Your Ref: OWPC16499
Our Ref: FG/172/17/HH 03-11-2017
Please ask for:
Mark Jones

Town & Country Planning Act 1990 (as amended)
Town & country Planning (Development Management Procedure) (England) Order 2015

Single storey rear extension.
5 Sark Gardens Ferring

Proposals 02 A

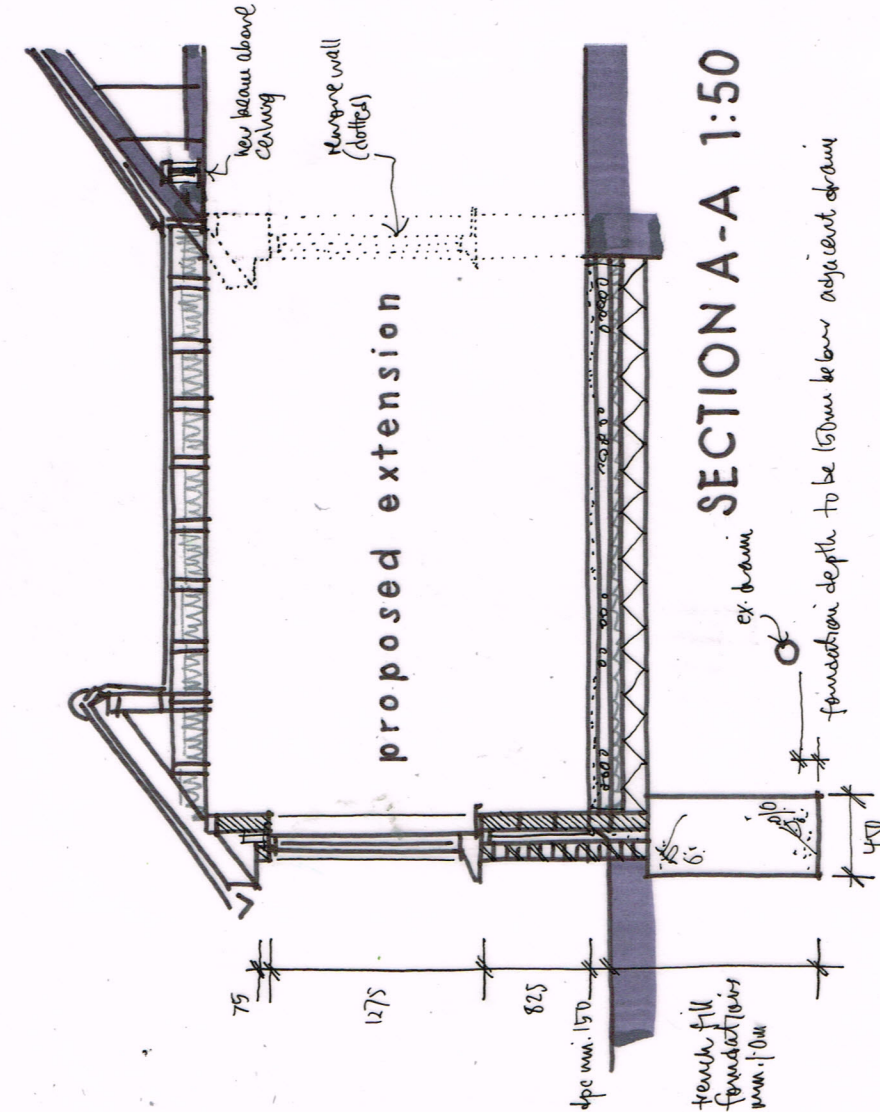
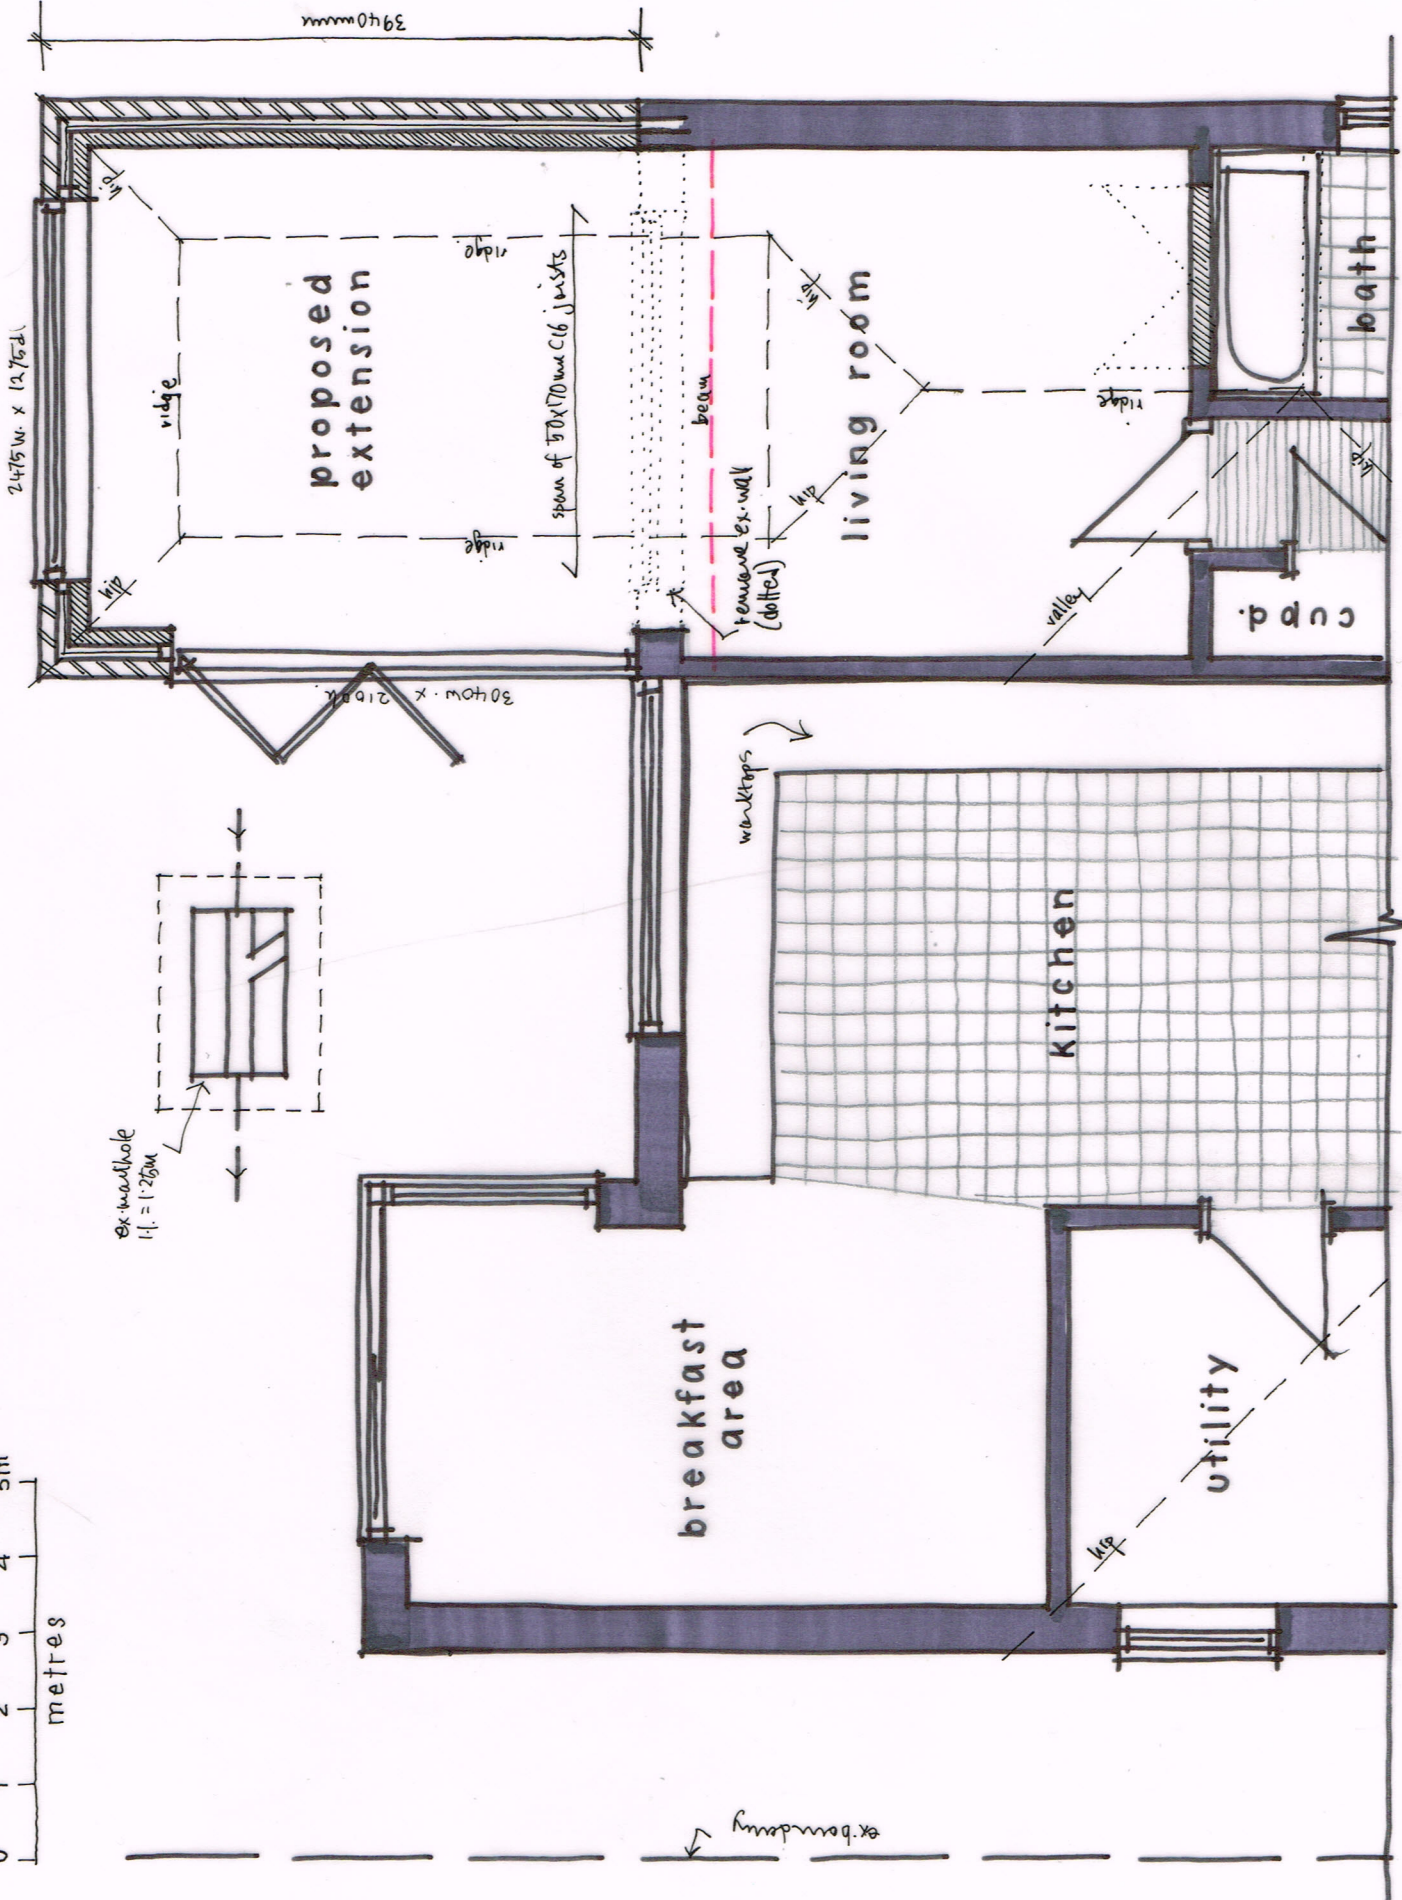
Section 11 of the application form has been completed stating that existing wall materials were render and brick. This is incorrect as it was in fact only brick. The rendering commenced on 19/10/17. Rendering is not in keeping with our and the other properties on the street. Painted render will also cause sun reflection glare into two of our side windows facing the rendered wall.

Proposed plans do not depict any bedrooms.

The single storey extension is built over a public sewer without prior Southern Water approval.

SIDE (W) ELEVATION 1:100 @ A3

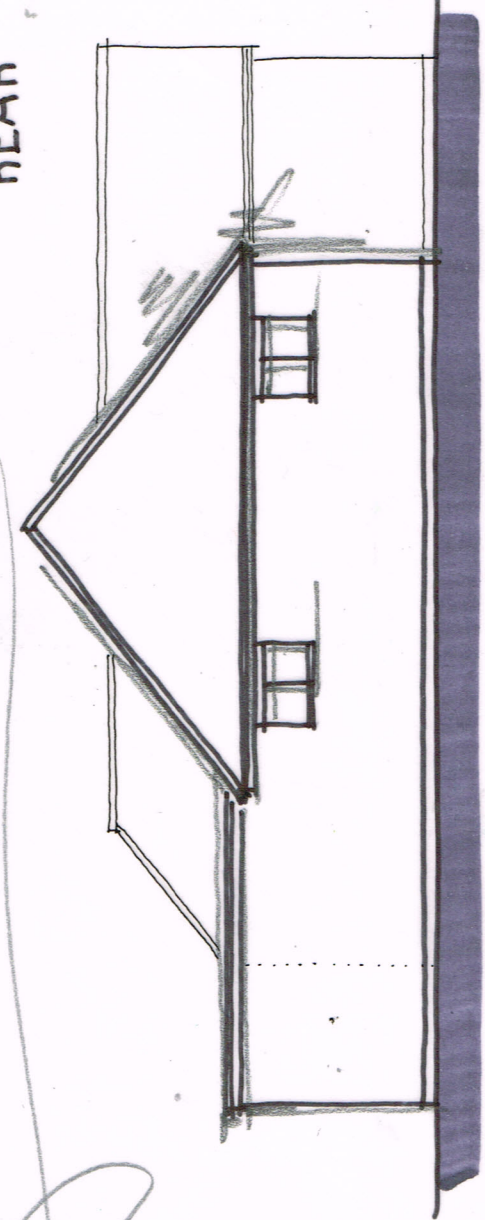
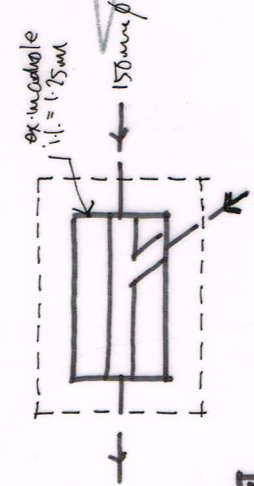
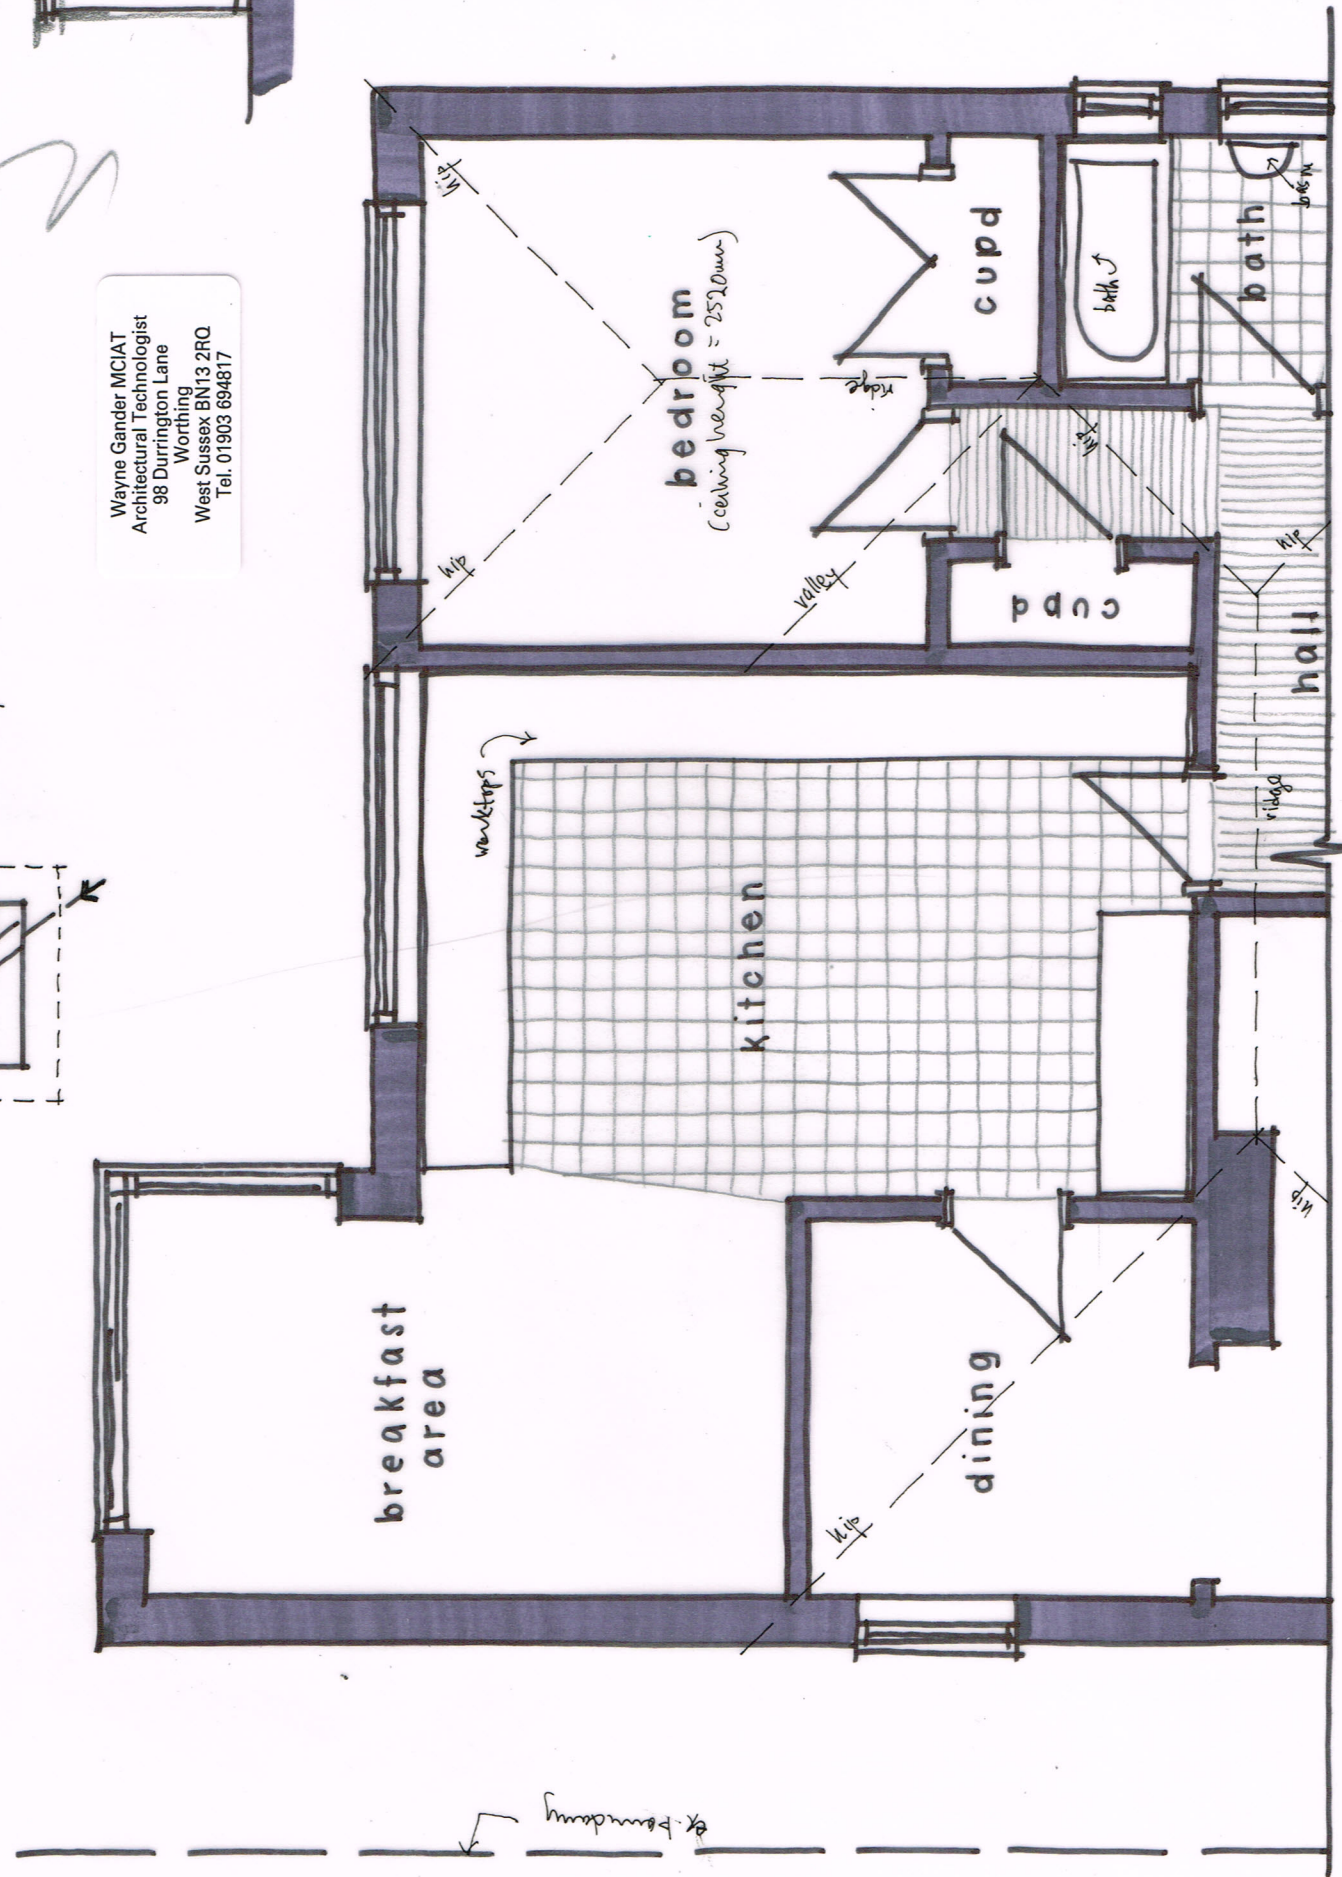
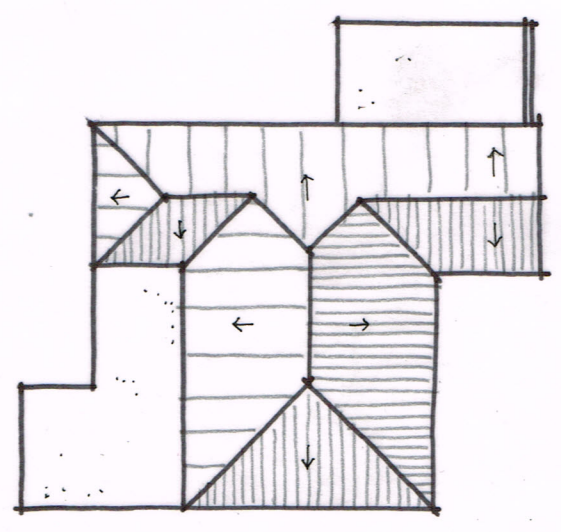
No Party Wall Act notice was served to us or our permission sought to remove the adjoining asbestos garage roof and the adjoining garage coving brickwork (which has been removed for weeks now, causing potential damage to our property). Existing September 2017 plans submitted are drawn after modifications to the original building had commenced. External doors and windows had been already removed and replaced.
